# City of Albuquerque Stormwater Construction Site Inspection Report

General Information				
Project Name:	Storm Cloud Estates			
Location:	Tierra Pintada			
Site Contact Name & Agency	Kevin Griffin DR Horton	ESC File No.	H09D022B	
		NPDES Id. No.	NMR10012Y	
Inspection Date:	04/15/19	Start/End Time:	0730/0900hrs	
CoA Stormwater Inspector:	Timothy Sims, Stormwater Inspector			
Construction Phase:				
Type of Inspection:	<input type="checkbox"/> Regular	<input type="checkbox"/> Storm Event	<input type="checkbox"/> Post Storm Event >0.25"	<input checked="" type="checkbox"/> 311/Complaint
	<input type="checkbox"/> Follow Up

**Erosion Sediment Control Plan**

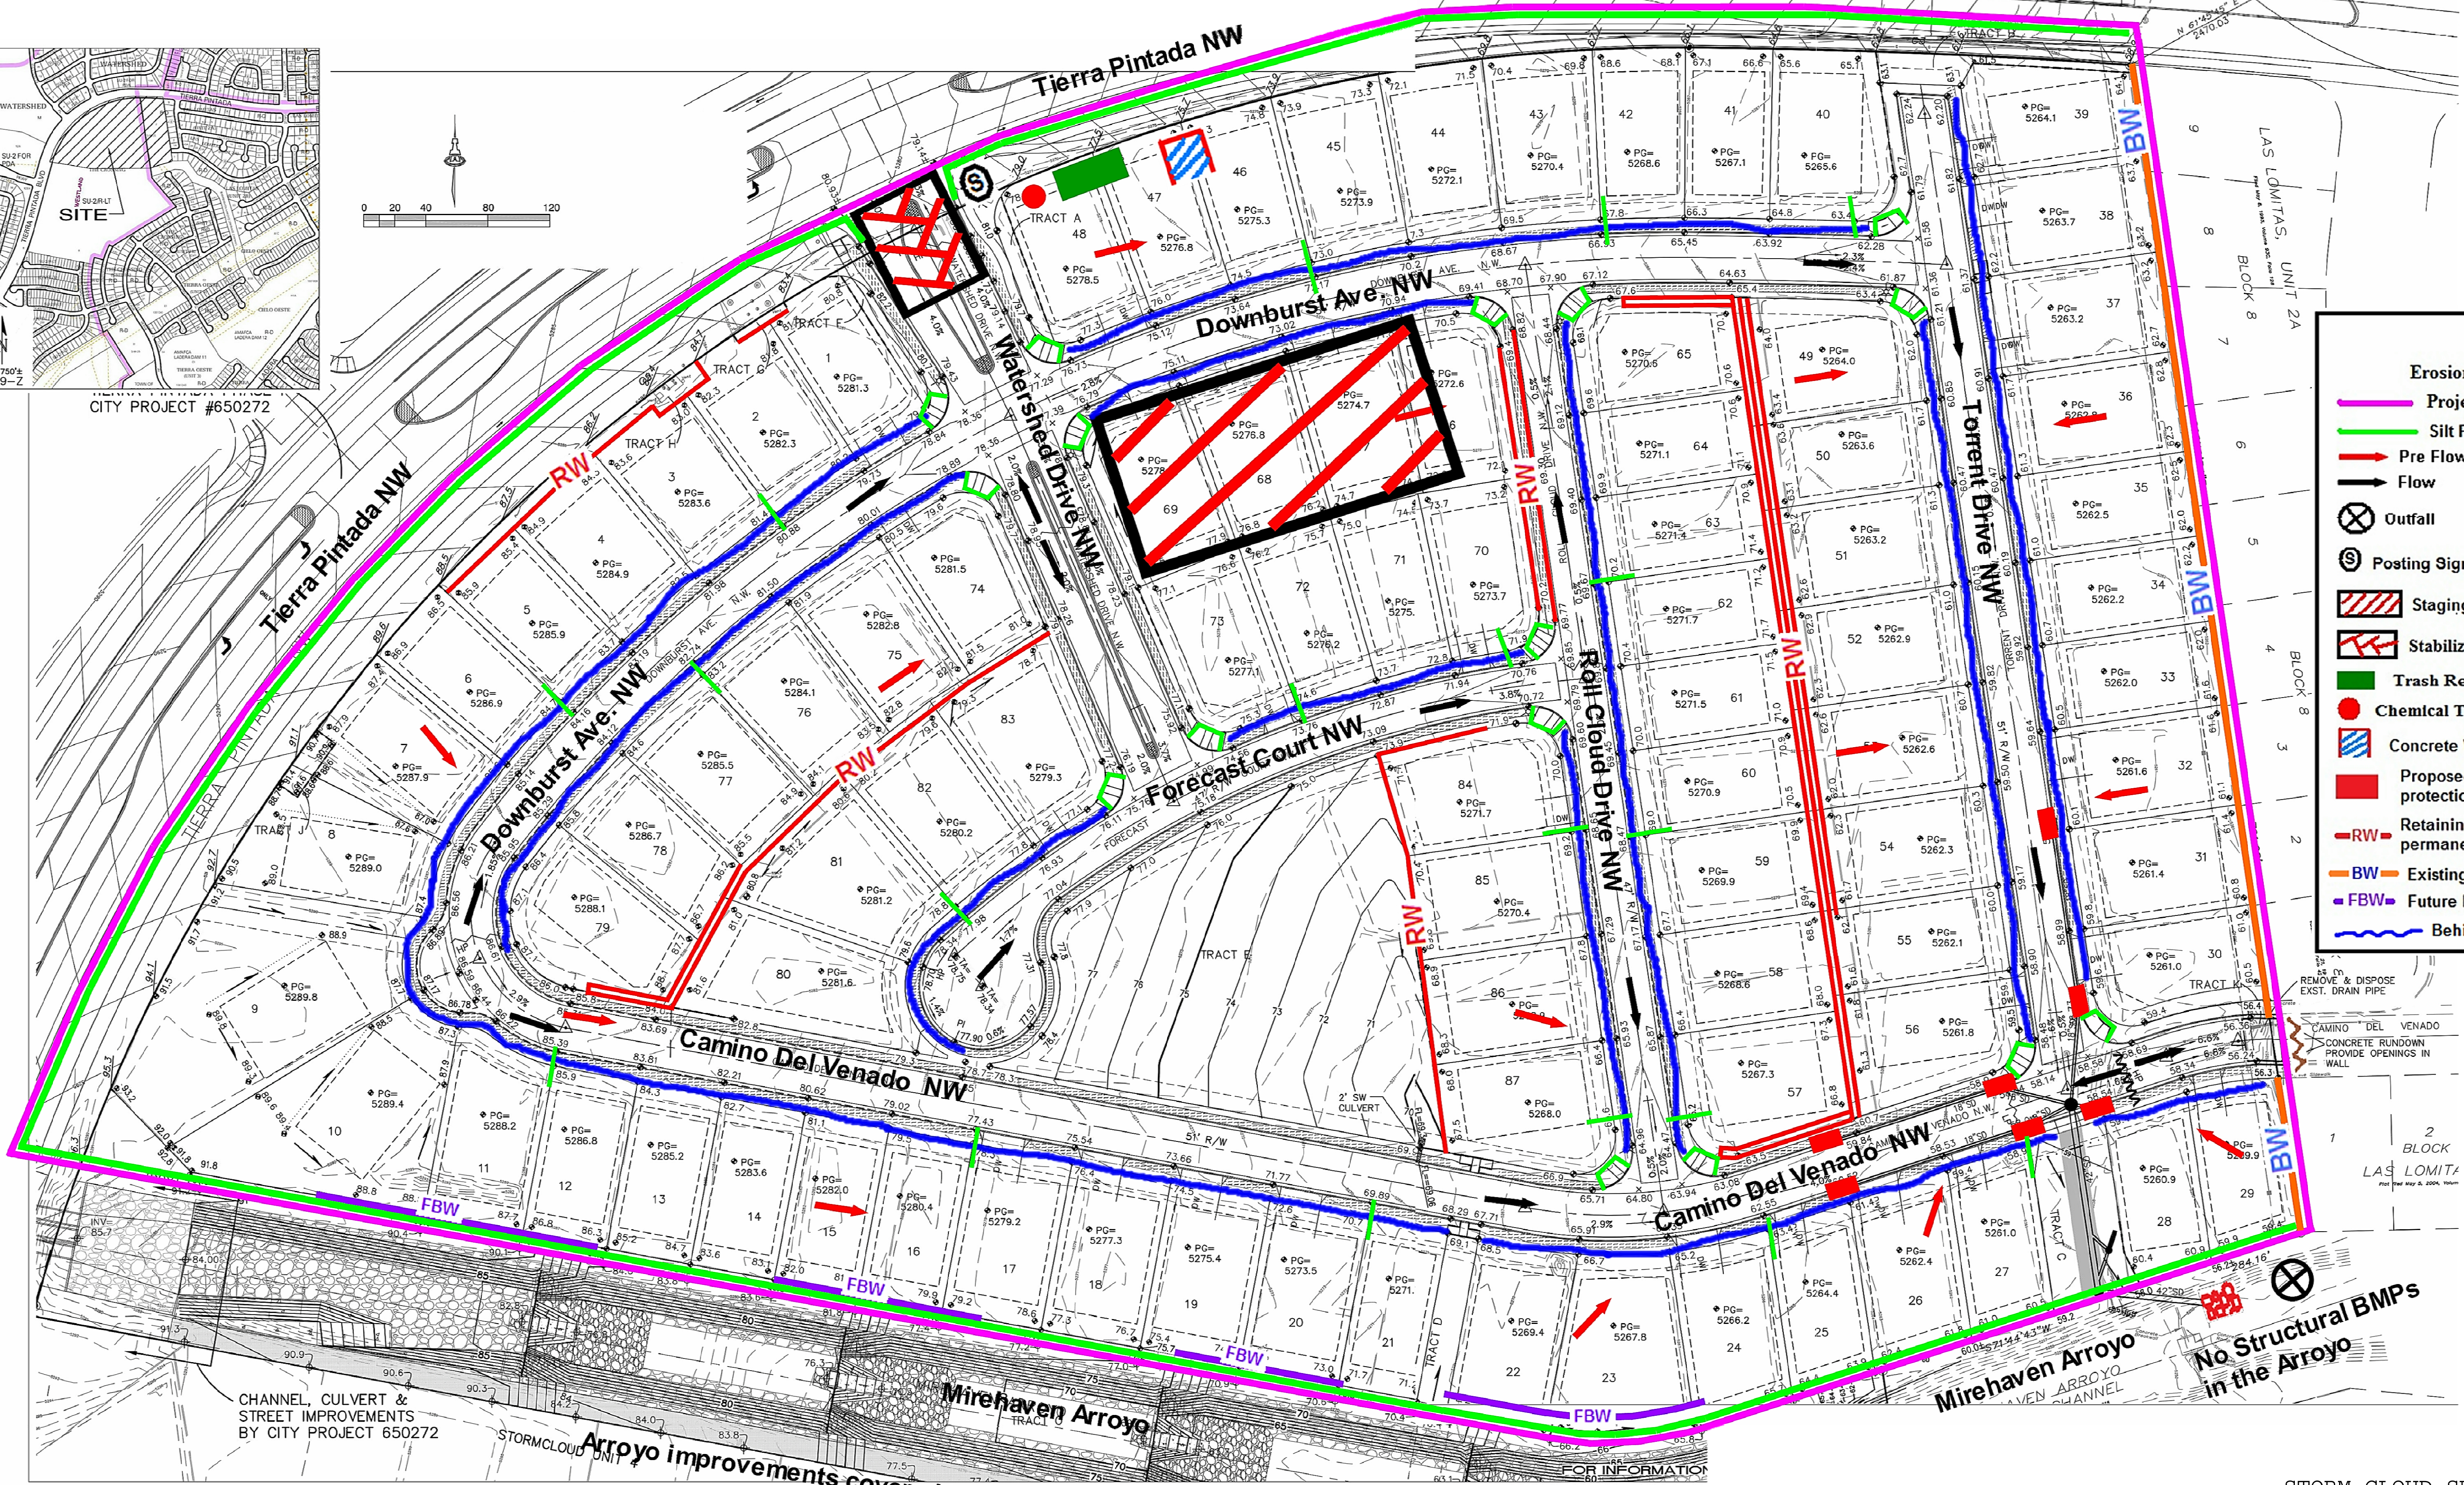
Item Number	Deficiency/ Corrective Action		
	8815 Down Burst		
1	Other than Lumber debris in front yard- clean and remove to acceptable refuse container.		
2	minor washout on east side of driveway. Mitigate and traing subs about washout preventing future issues.		
	8608 Camino de Venado		
3	re-set and stake portable toilet- staking assists with topledge		
	2100 Roll Cloud Dr		
4	mitigate washout (clean and remove) washout in front yard. It appears sheetrock or paint washout occurred at this location.		
	8604 Down Burst		
5	re-set and stake portable toilet- staking assists with topledge		
6	Sediment in Streets of subdivision are showing signs of wind blown sediment. Please remove sediment and provide maintenance on drop inlet BMP's.		
2.1	Discharge off site? (Y/N)	No	
4	Self Inspection Reports	requested	Latest report Date:

Maintenance or corrective actions are to be completed within seven (7) days.
